**Consultation Response from KC, Highways Development Management (HDM)**
**2023/92448 Former Cooper Bridge Water Treatment Works, Leeds Road, Mirfield, WF14 0BT**
**Outline application for erection of B8 industrial unit**
**Date Responded: 25/10/23**
**Responding Officer: A Darwin**
**Responding Ref: HDC 10-2NW/1**
**RECOMMENDATION: Further information and amendments required**

KPP Job No	Rev
2172	.
Number	
2000

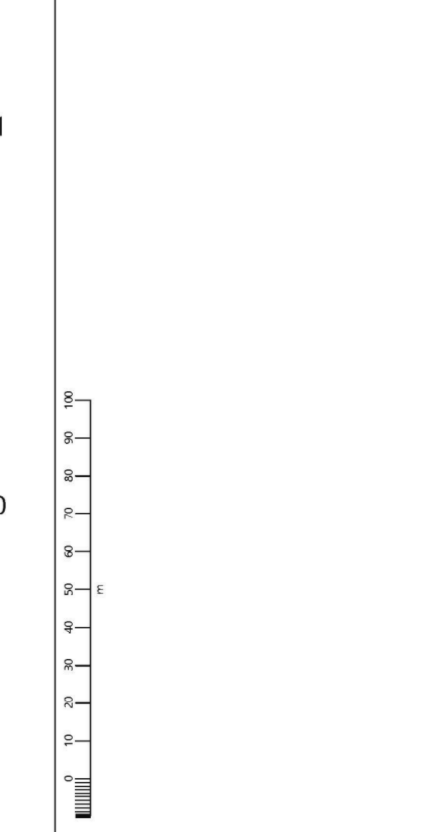
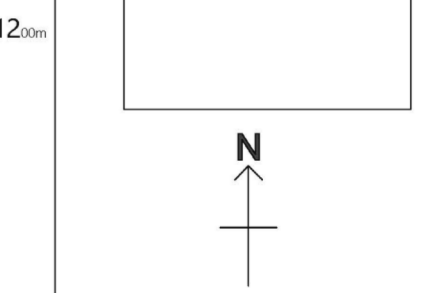
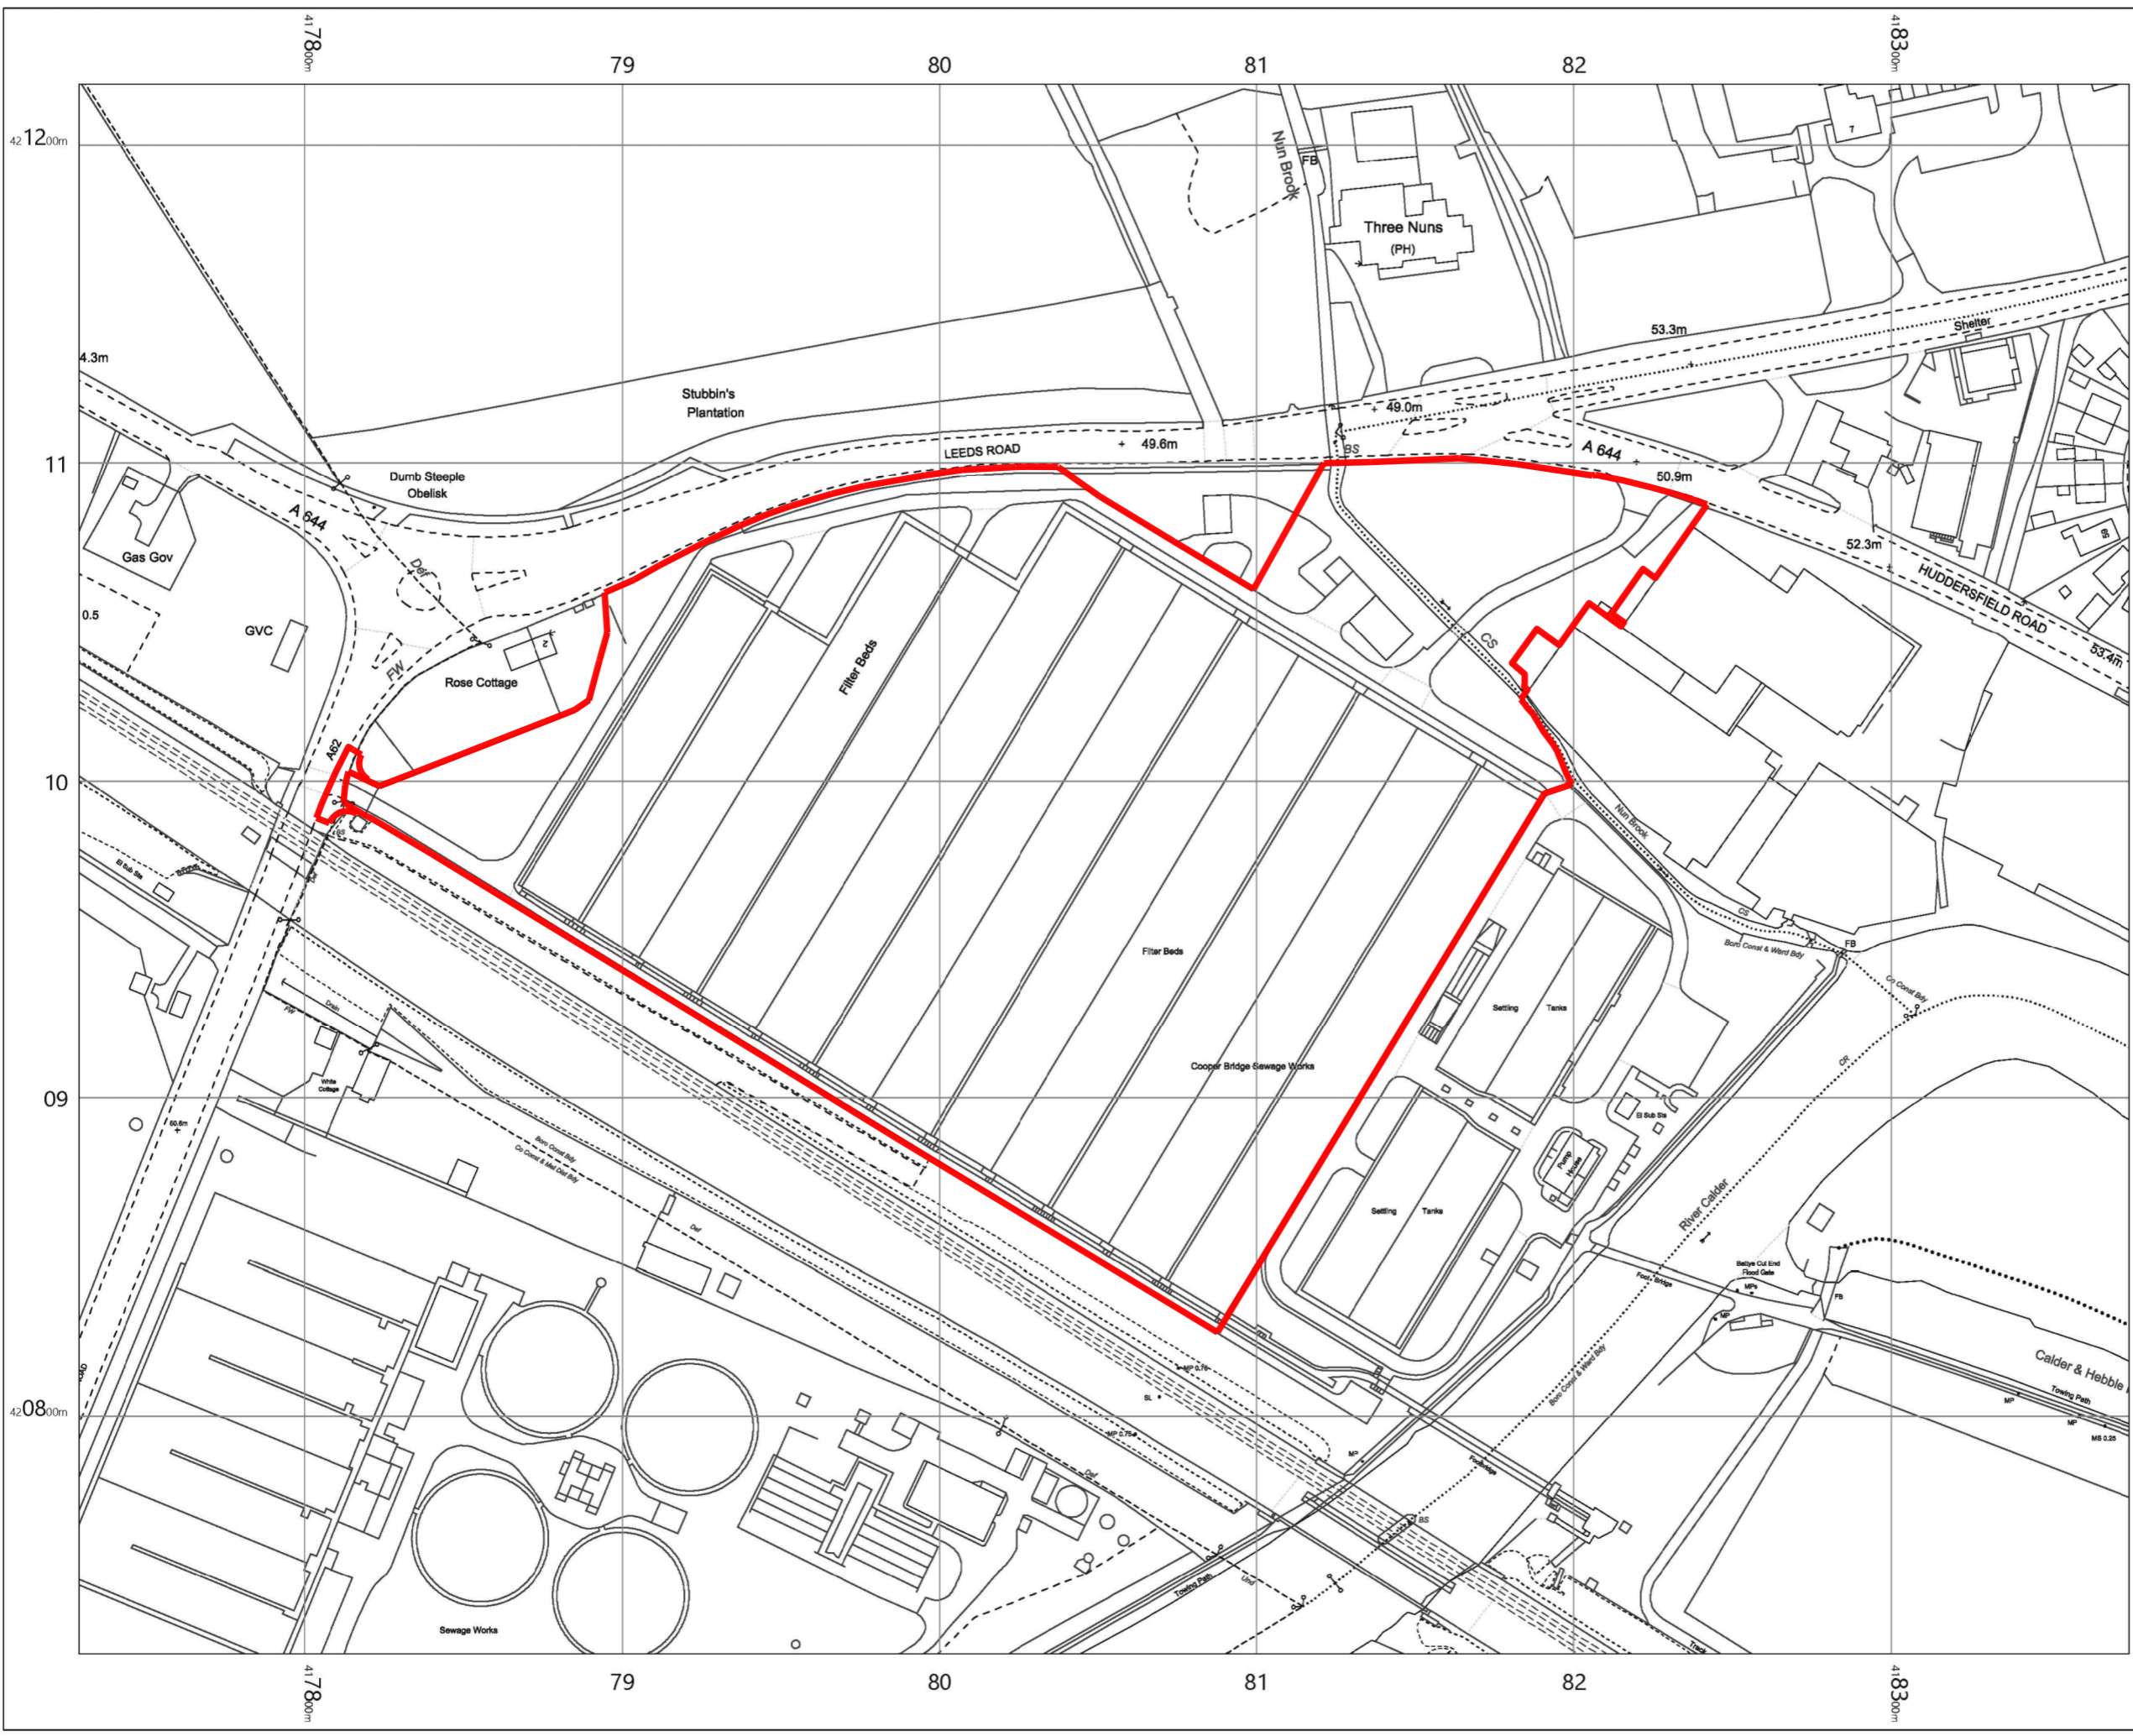
- Based on the necessary changes to this site access design, it is clear that land beyond the applicants site boundary to the north (that has been procured by Kirklees Council to deliver the wider Cooper Bridge improvement scheme) will be required to deliver an acceptable access arrangement, and the redline boundary for the planning application will need to be amended (HDM have already identified this matter to the Planning Officer).

- No details of junction visibility have been confirmed in the Transport Assessment or the supporting plans. However, it is clear that junction visibility to the right on exit of the site access is not in accordance with DMRB requirements (e.g. below 2.4x120m based on 40mph speed limit) and is severely sub-standard. It is noted that it may be possible to address this issue by setting back the boundary wall in the existing John Cotton site to the east of the access. However, this will have implications on the existing parking area and service yard, and the necessary amendments need to be identified. It is noted that these changes will also require further changes to the planning application red line boundary.

Number
2001

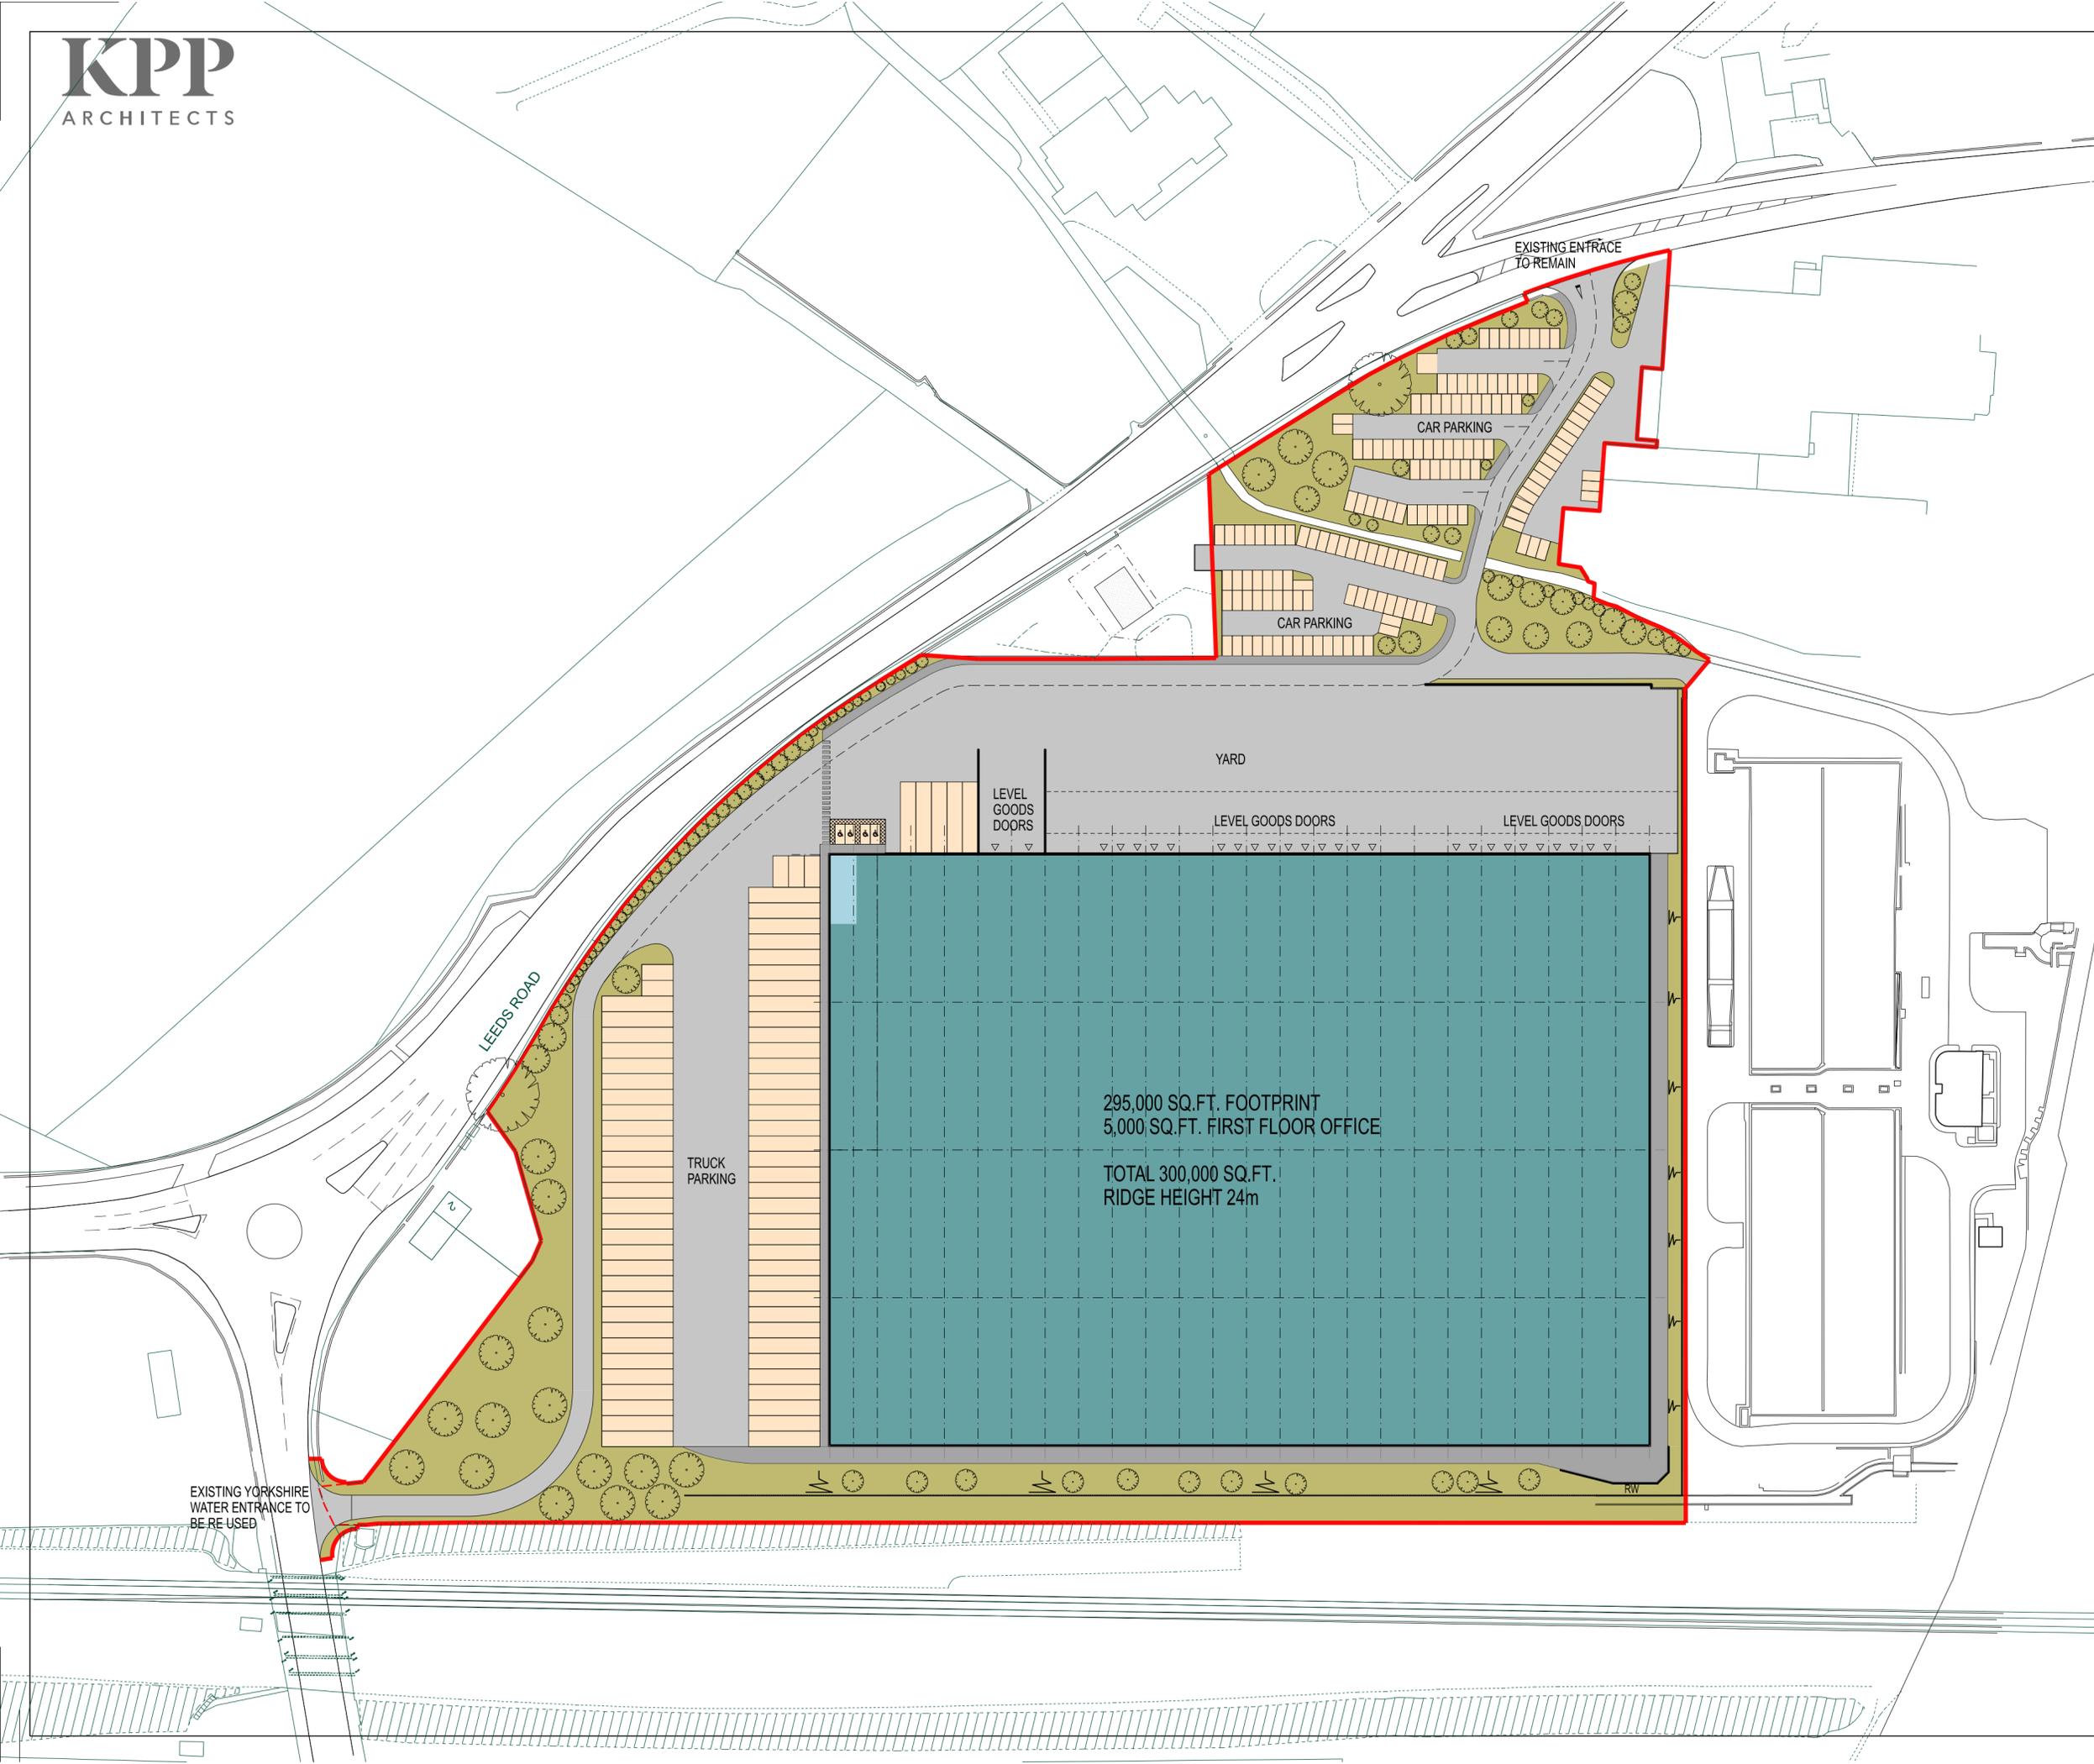
It is noted that the above car parking details are incorrect, as the proposals include replacement parking on both sides of the existing treatment works access on to Huddersfield Road, including parking areas to the east that are currently served from other existing John Cotton access points. Whilst layout and parking details have been identified as being reserved matters, a full understanding of the new/amended parking and access arrangements are required, as these matters have a direct impact on the new site access arrangements that would be established by this outline planning application. It is noted that additional changes within the existing John Cotton site may be necessary to accommodate these changes, which need to be clearly identified and included within the sites redline boundary.

- The Huddersfield Road access is also proposed to serve an area of existing car parking within the existing John Cotton site to the east, which is proposed to be rearranged. However, no details are provided of the wider changes within the existing John Cotton site that are proposed. Therefore, it is unclear how these changes may affect traffic flow within the existing site and the other existing accesses on Huddersfield Road, which needs to be clarified.

- As previously stated, the proposals include changes to the existing parking/servicing arrangements in the existing John Cotton site to the east. These physical changes and their impact on the existing site use need to be clearly identified, including details of how this will affect access to/from the existing site.

However, based on the submitted information, it is unclear what provision is currently envisaged, as the reports and plans suggest that 140 new car parking spaces are proposed, but 154 spaces are shown on the plans, some of which appears to be replacement parking for the existing John Cotton site.

Whilst the planning application is in outline only, the indicative masterplan should be updated to demonstrate that adequate parking can be made available for all modes based on the scale of development proposed, and good quality access to/from these facilities are made available.
